**Section 96A of the Town & Country Planning Act 1990 (as amended)
Town and Country Planning (Development Management Procedure) (England) Order 2015 (as amended) - Article 10**

Application for A Non-material Amendment Following a Grant of Planning Permission

Development Non-material amendment following the grant of reference Y/32/19/RES for insertion of bio-bubble & associated cabinet, change number of windows & aperture size on front elevation, remove set of double doors on rear elevation of entrance hall, addition of flue on south facing roof slope and change doorway to bike store

Location Lake Barn Maypole Lane Yapton

Project:
House for Jim and Linda Payne, Land Adjacent to Lake Barn,
Maypole Lane, Yapton, Arundel, West Sussex BN19 0DR
Drawing Title:
Roof plan

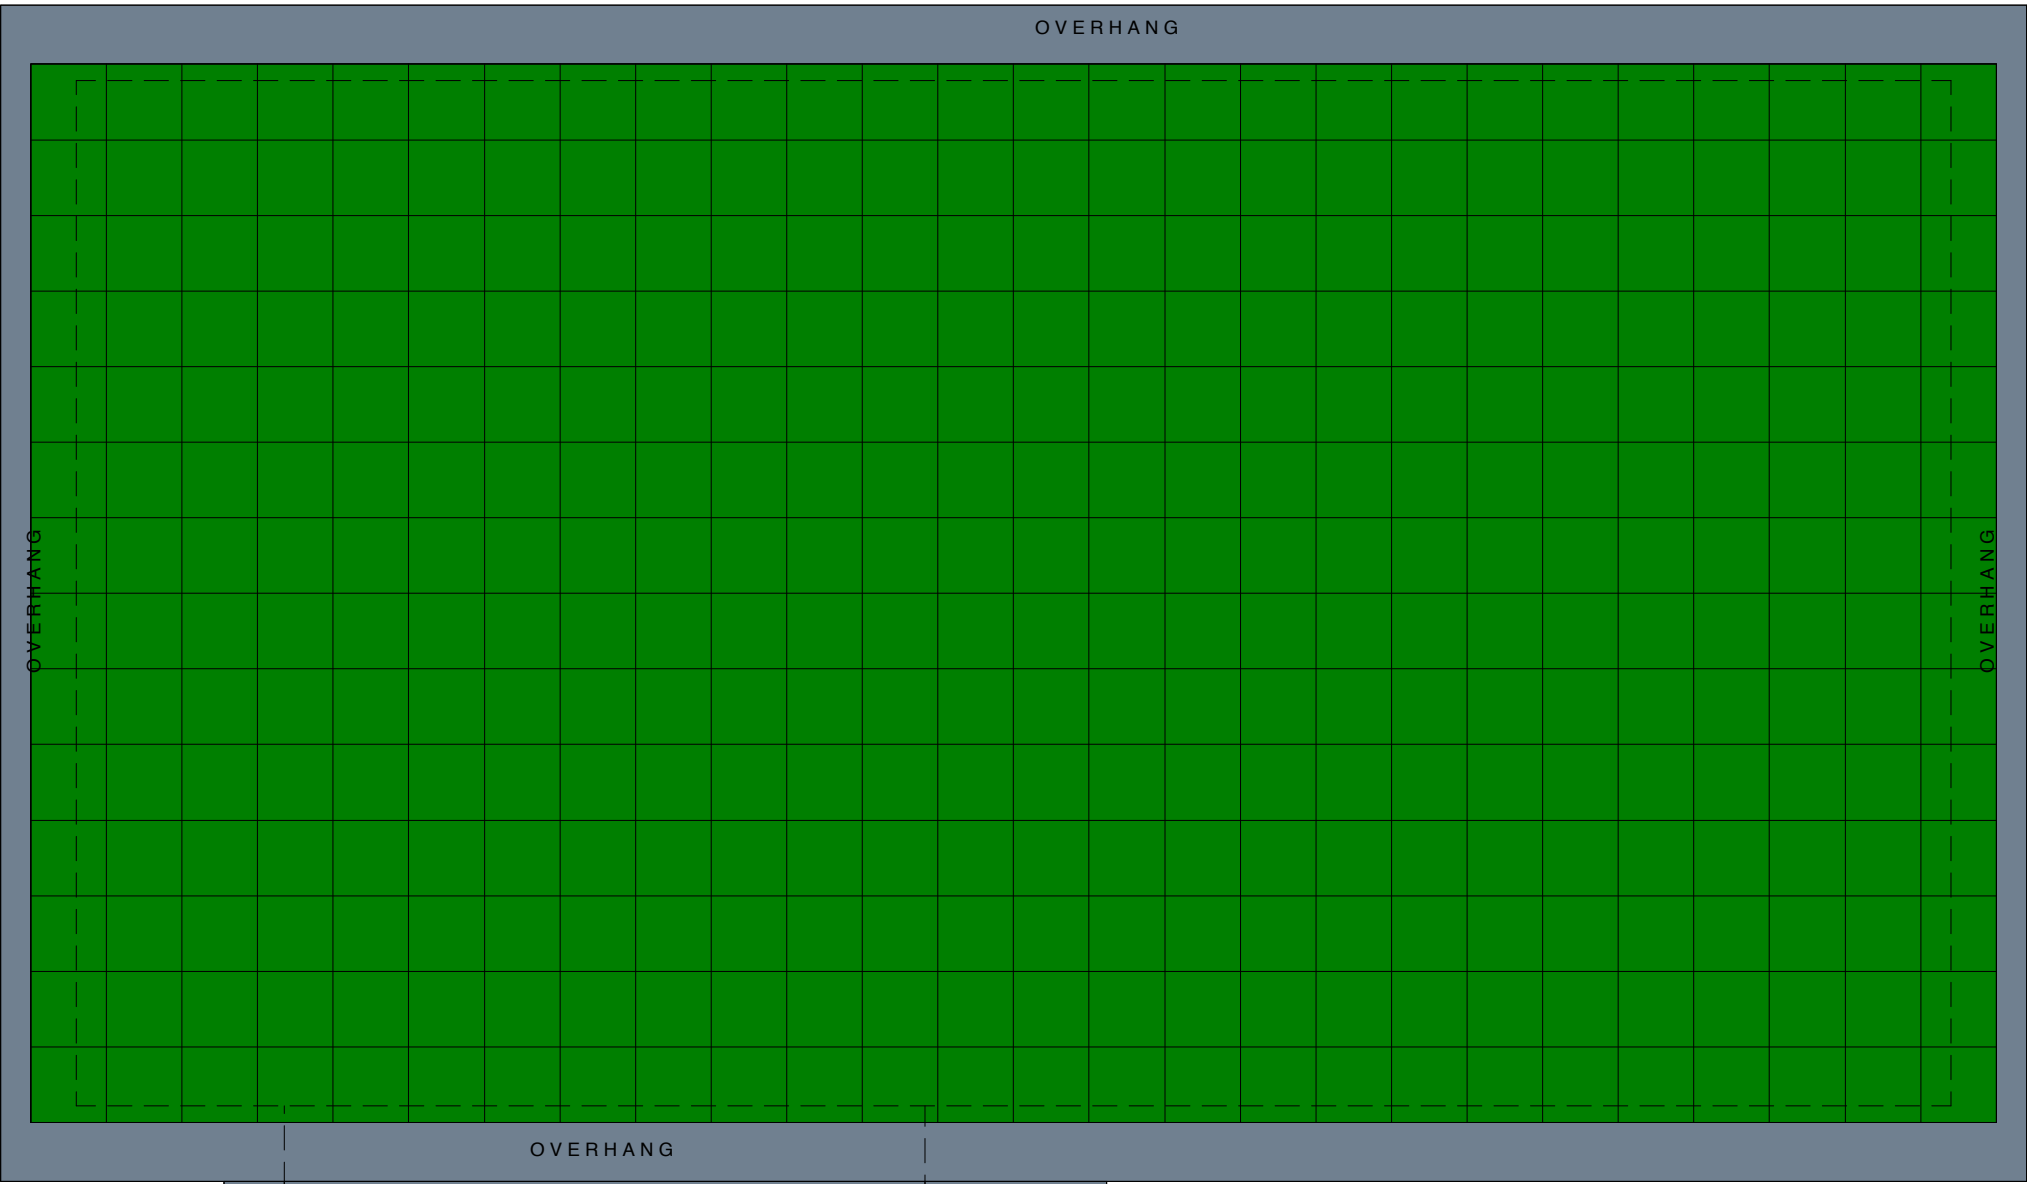
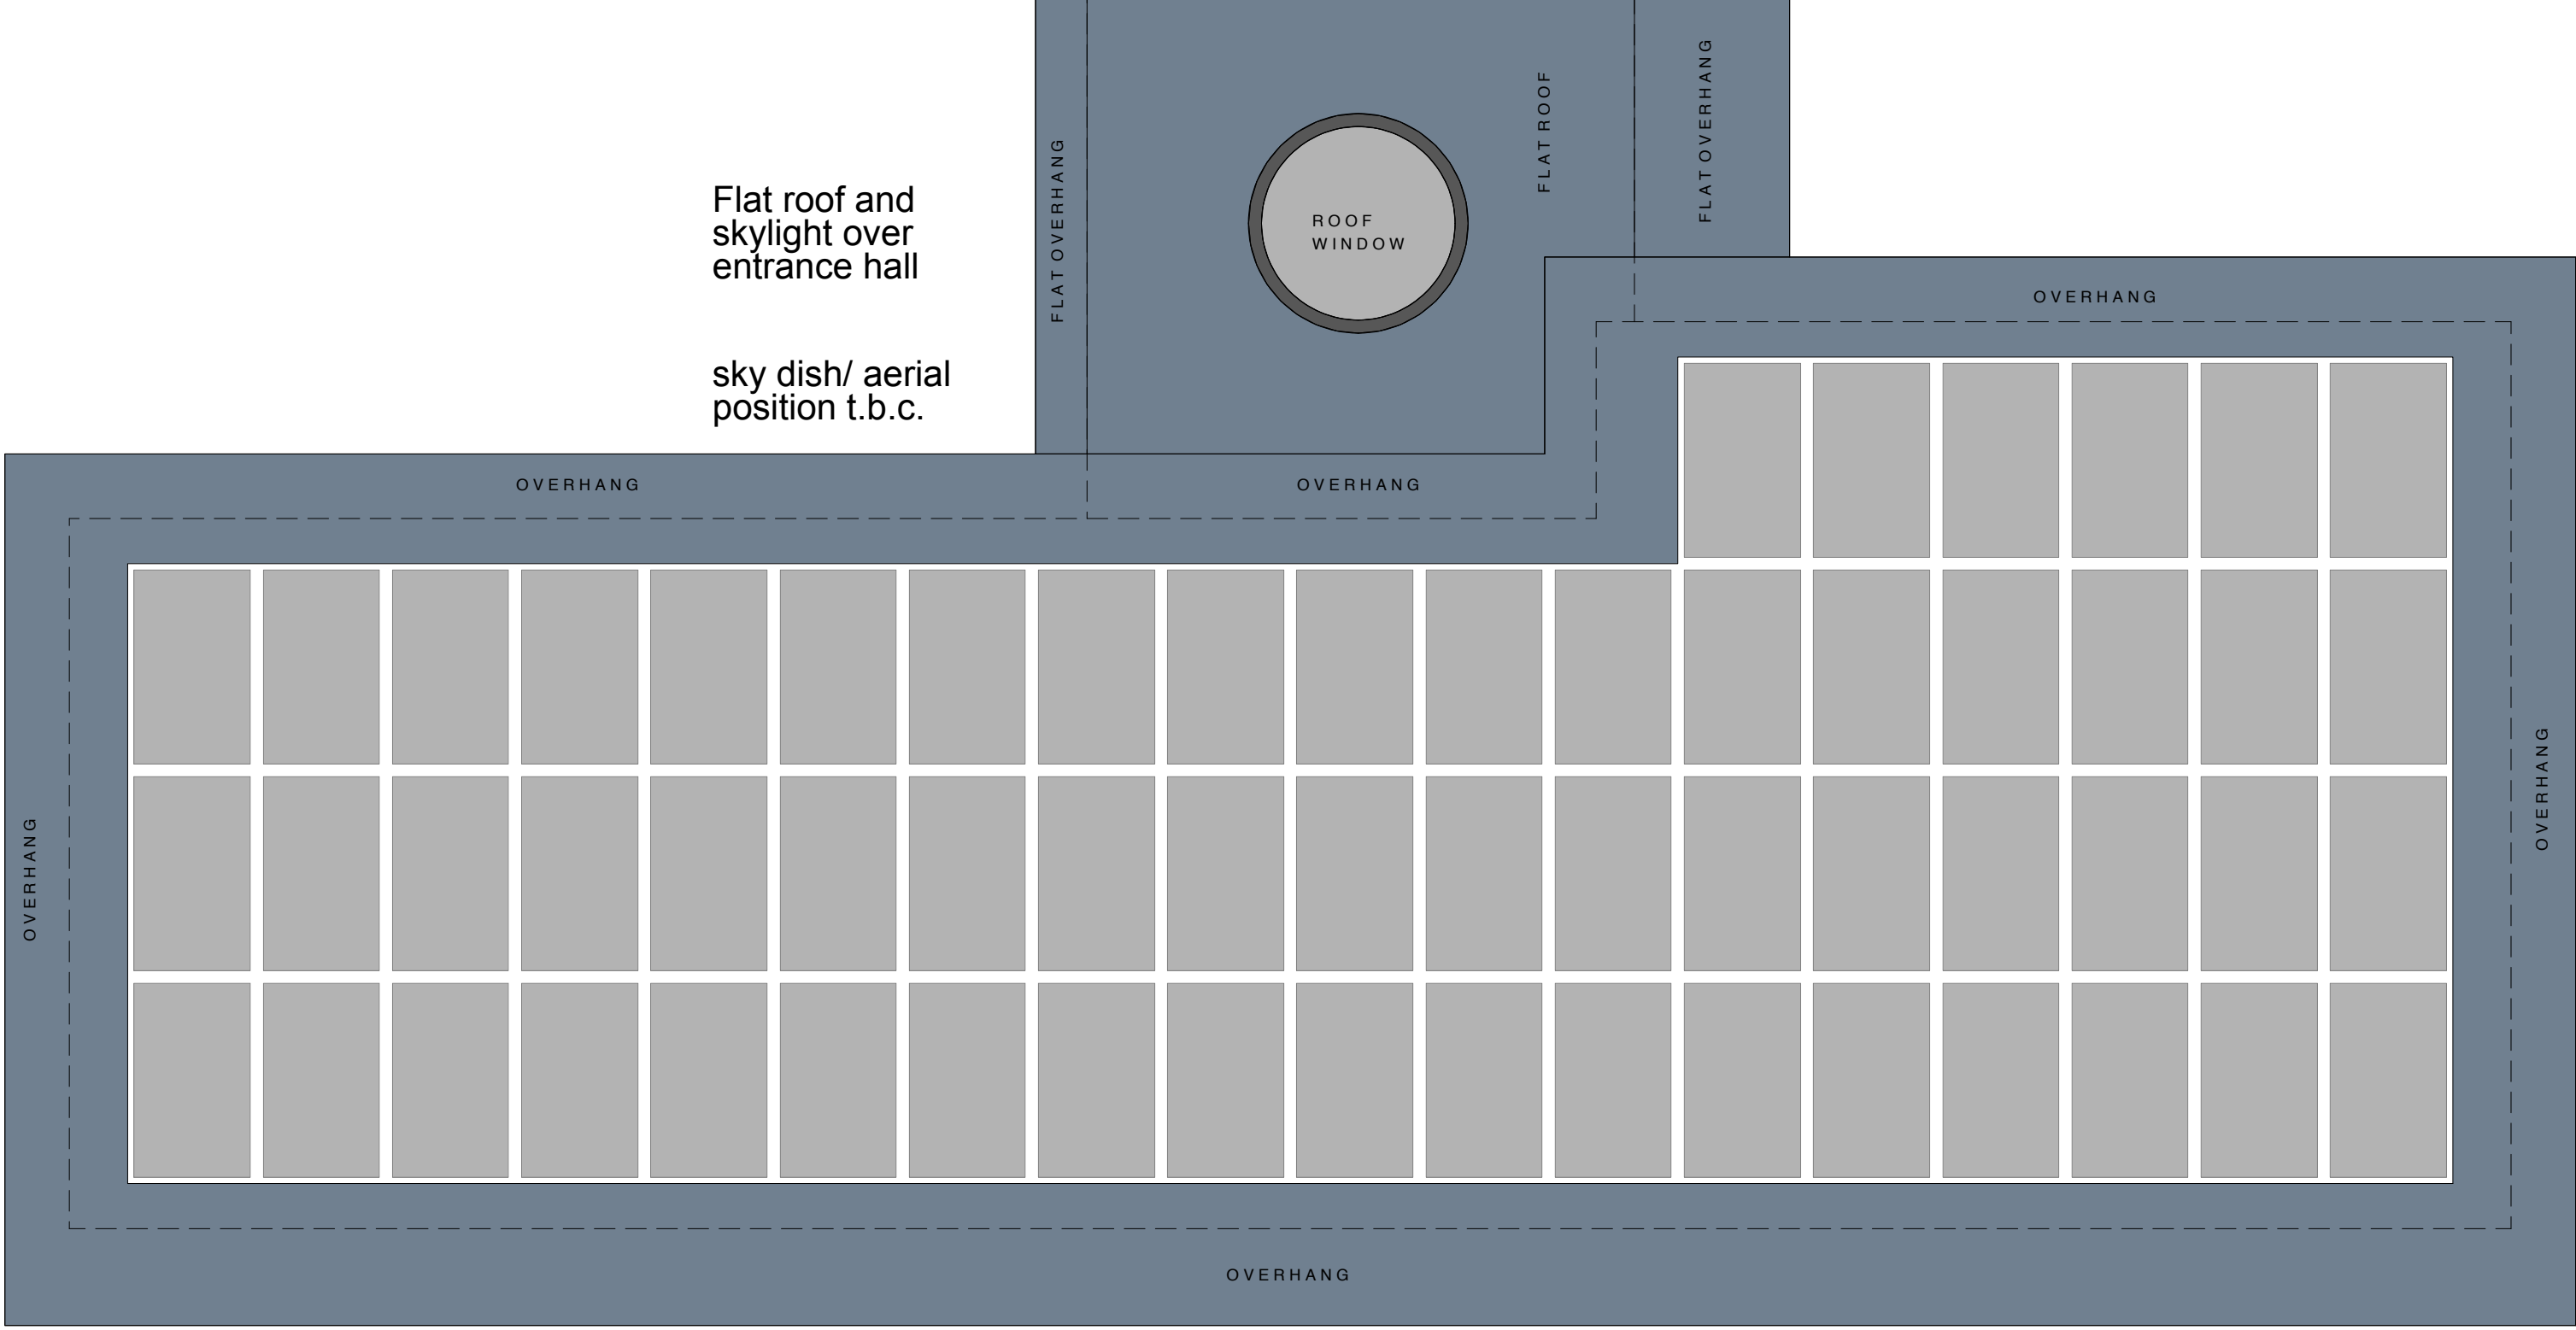
The flue does not appear to be shown on any of the new plans submitted. Please amend accordingly and re submit.

CLIENT		DRAWING TITLE :-	
PRINCIPLE CONTRACTOR		6 PE W.W.T.P	
CIVIL CONTRACTOR		1.8m I/D x 3m DEEP	
DRAWING No :-		BB-S3001	
UNITS IN mm		SCALE AS SHOWN	
A1		SHEET 1 OF 1	
REV 0		REV 0

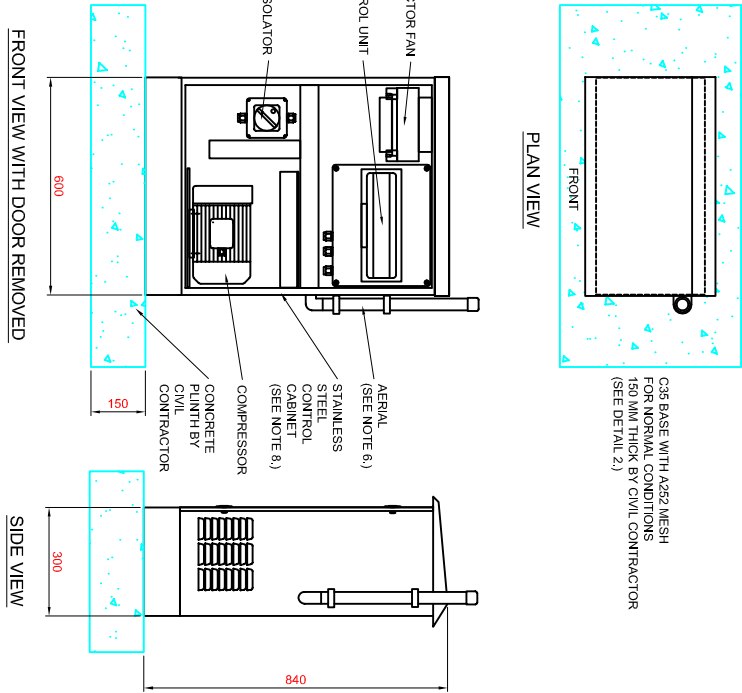
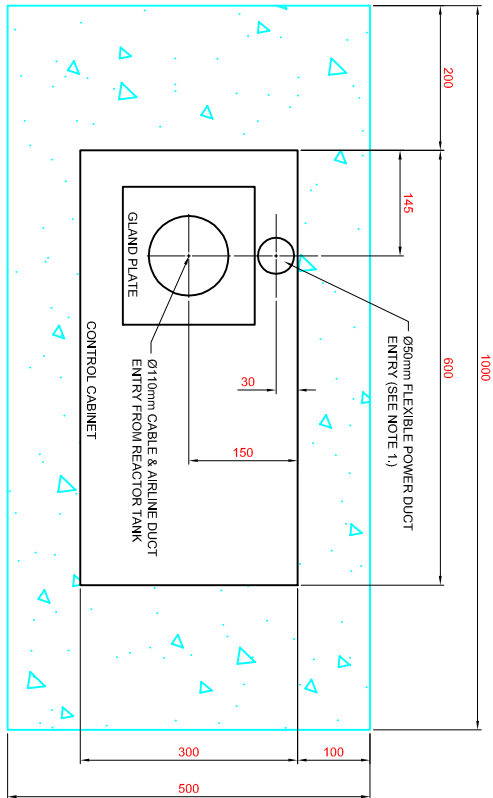
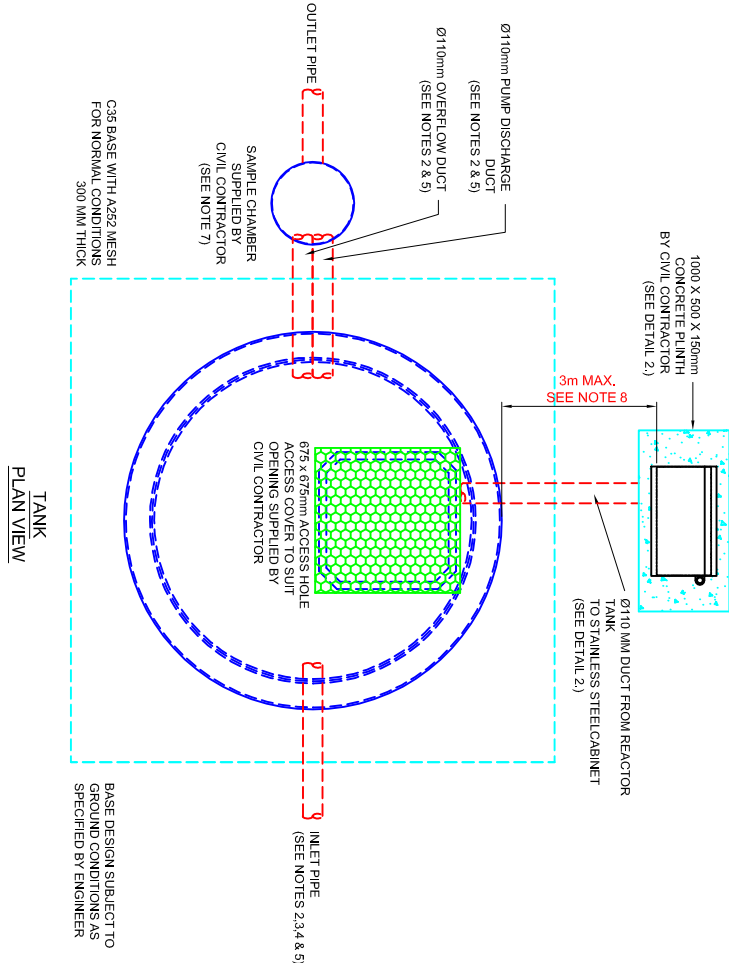
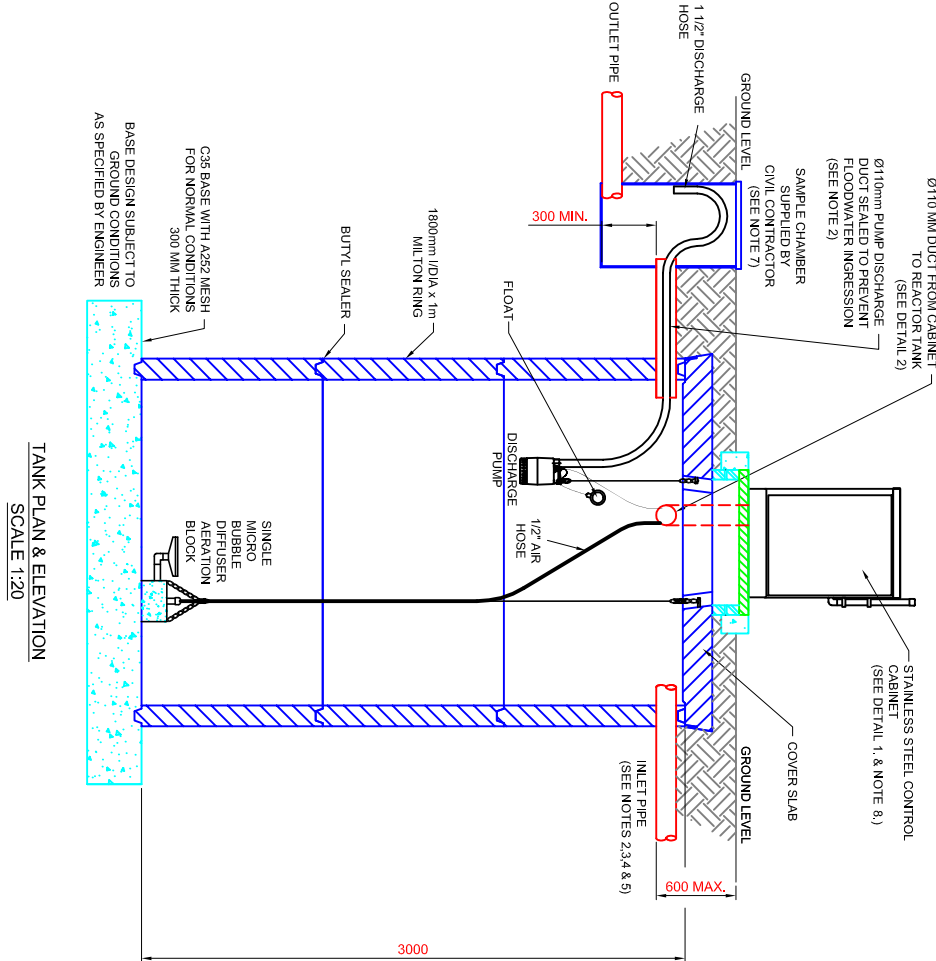
Please submit elevational details and a block plan at 1:200 of the bio bubble cabinet.
